Application for removal or variation of a condition following grant of planning permission.
Town and Country Planning Act 1990.
Planning (Listed Buildings and Conservation Areas) Act 1990

Unit:		House number:	1-12	House suffix:	
House name:					
Address 1:	Keresgorth Close				
Address 2:					
Address 3:					
Town:	Burnsley				
County:	South Yorkshire				
Postcode (optional):	S70 6RS				
Description of location or a grid reference. (must be completed if postcode is not known):					
Easting:		Northings:			
Description: Regurbishment of Former NHS Residential Units & External works

Conversion of disused former NHS residential accommodation into 13 Nr Dwellings (Now 12 Nr) & Associated works

Reference number: 2018/0969 Date of decision (DD/MM/YYYY): 26/07/2018 (date must be pre-application submission)

CLIENT	BERNESLAI HOMES
TITLE	
PROPOSED FLOOR PLANS - PLOTS 11-12

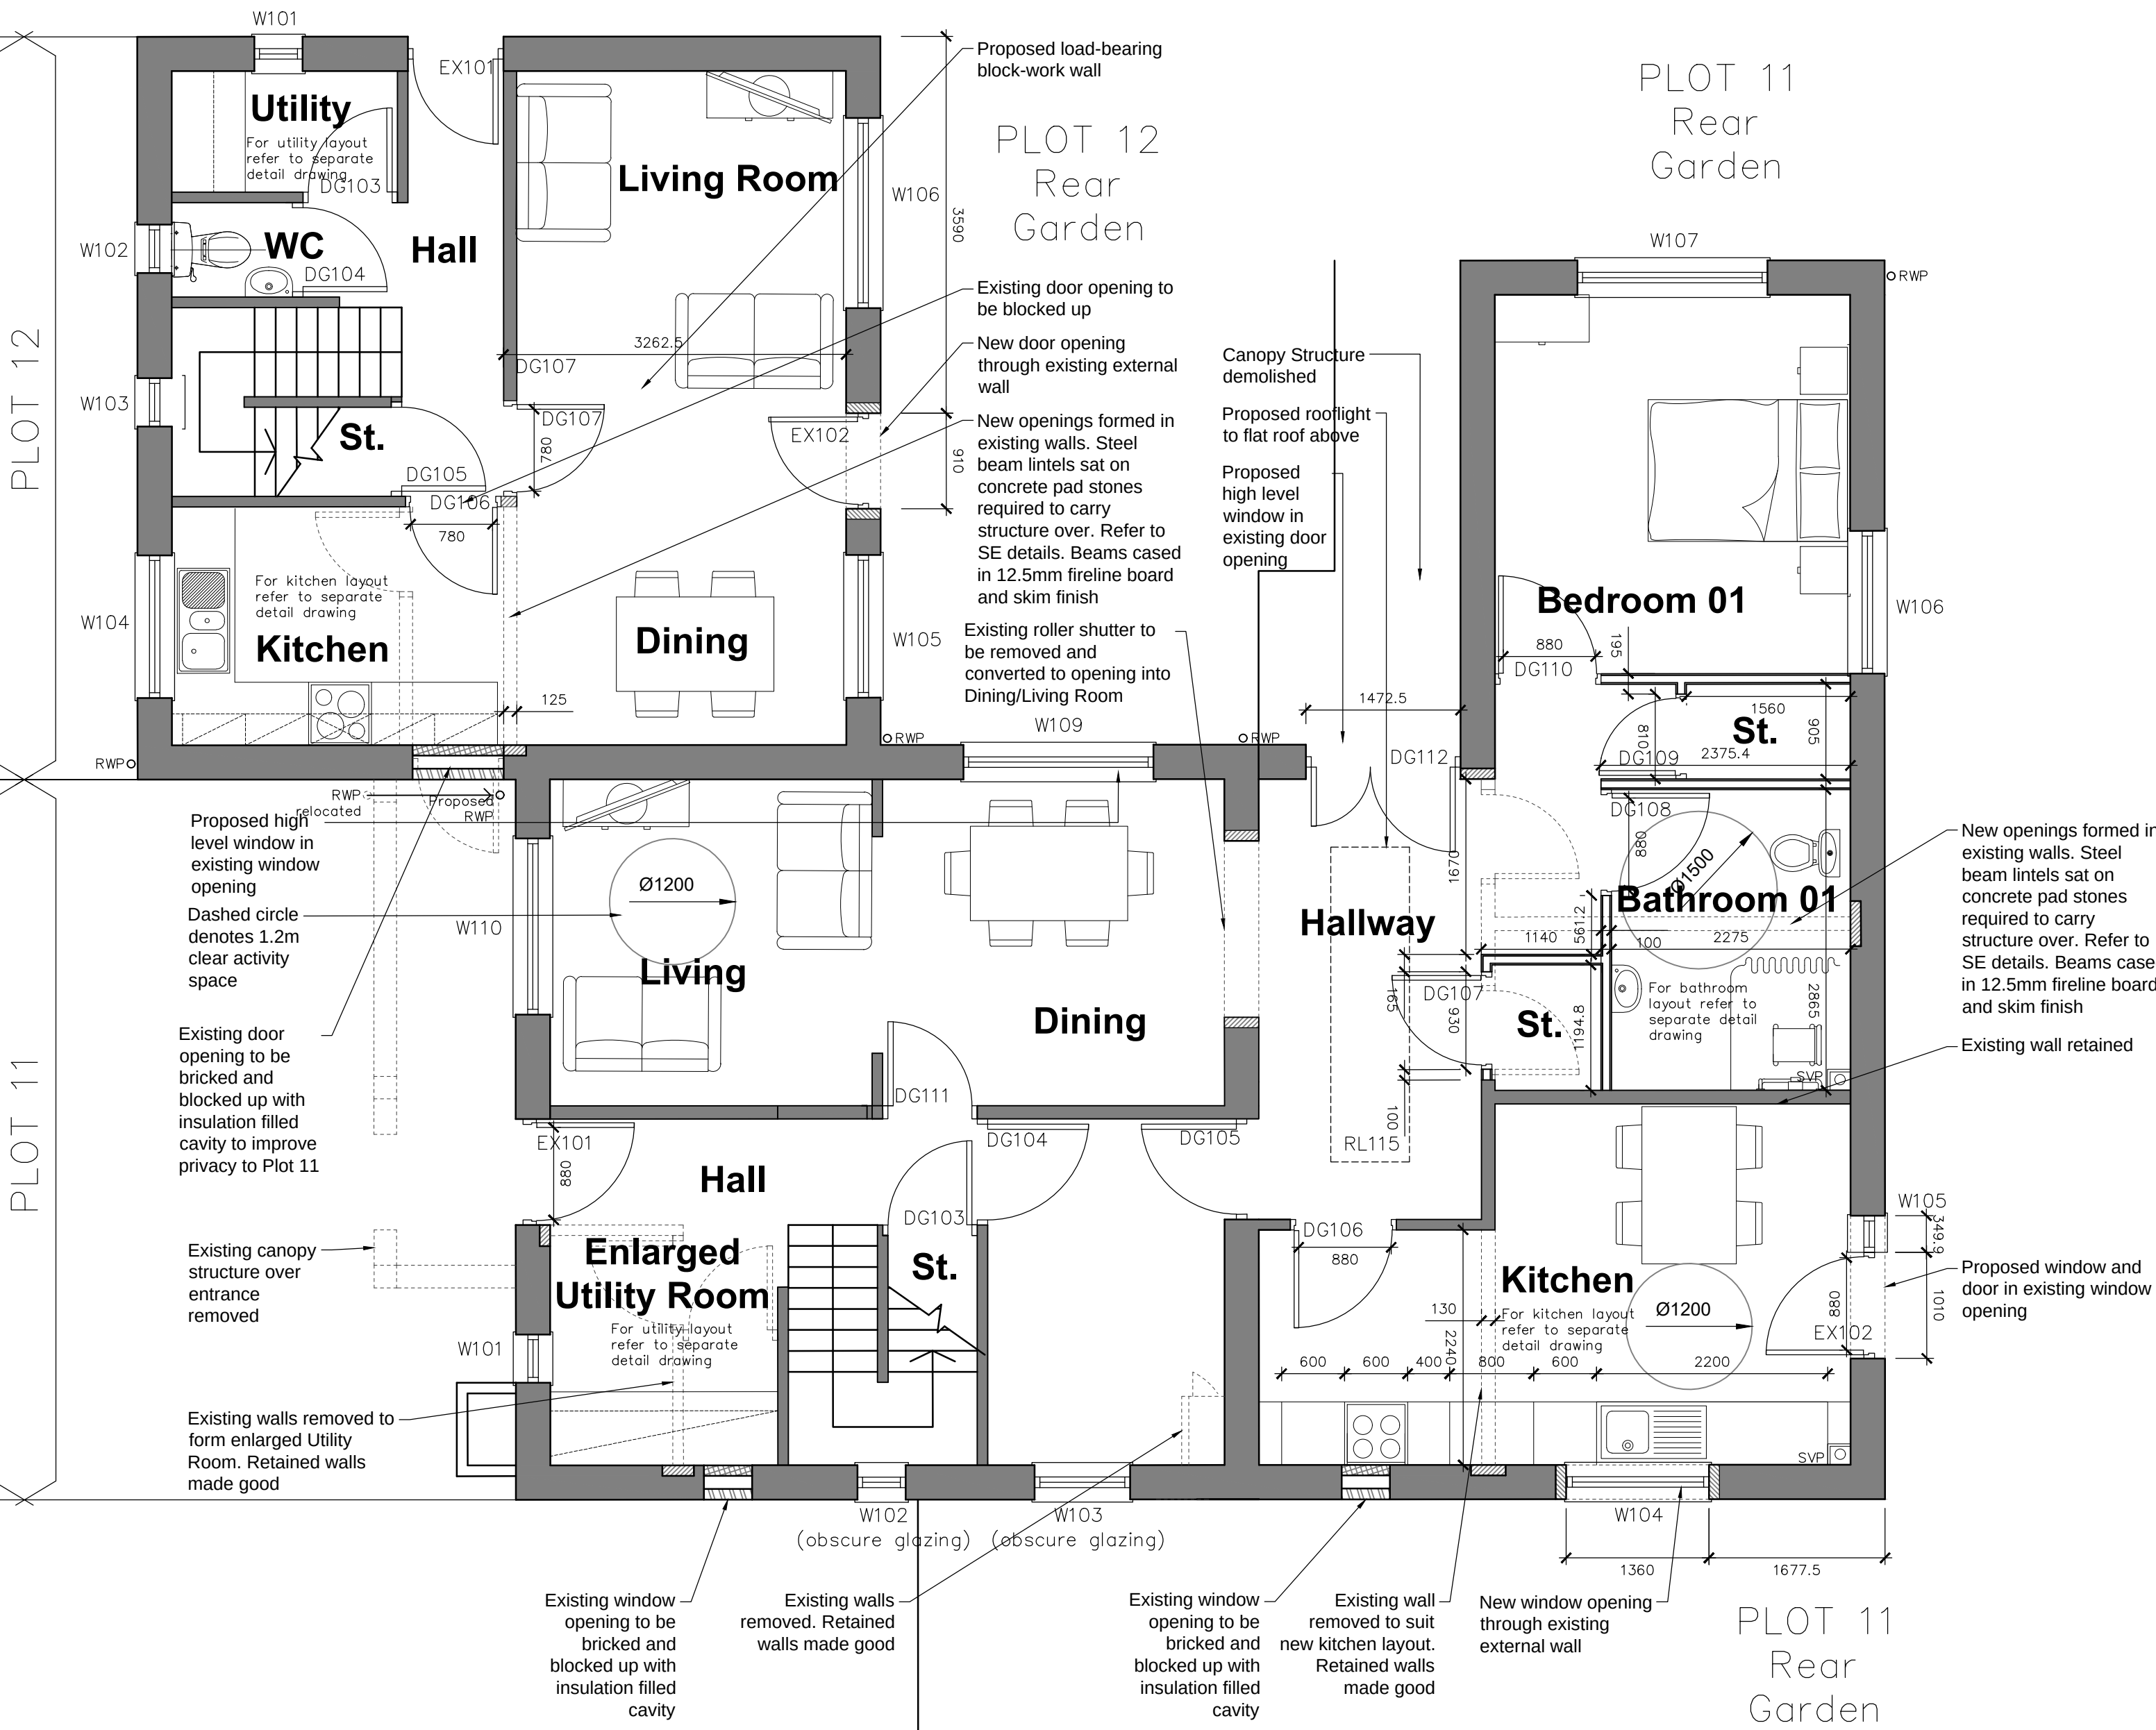
② - Revised Site layout proposed Reducing the Number of units back to 12 Nr - this allows for more economical turning area. window in plot 11 changed to Door For Disabled Access Route
④ - Reduced site arrangement gives minimal landscaping proposed - only turf & saplings

② - Revised in accordance with new proposed Drawings provided.
④ - Removed Due to minimal landscaping provided, existing shrubs removed & new turf Relaid + small number of saplings introduced
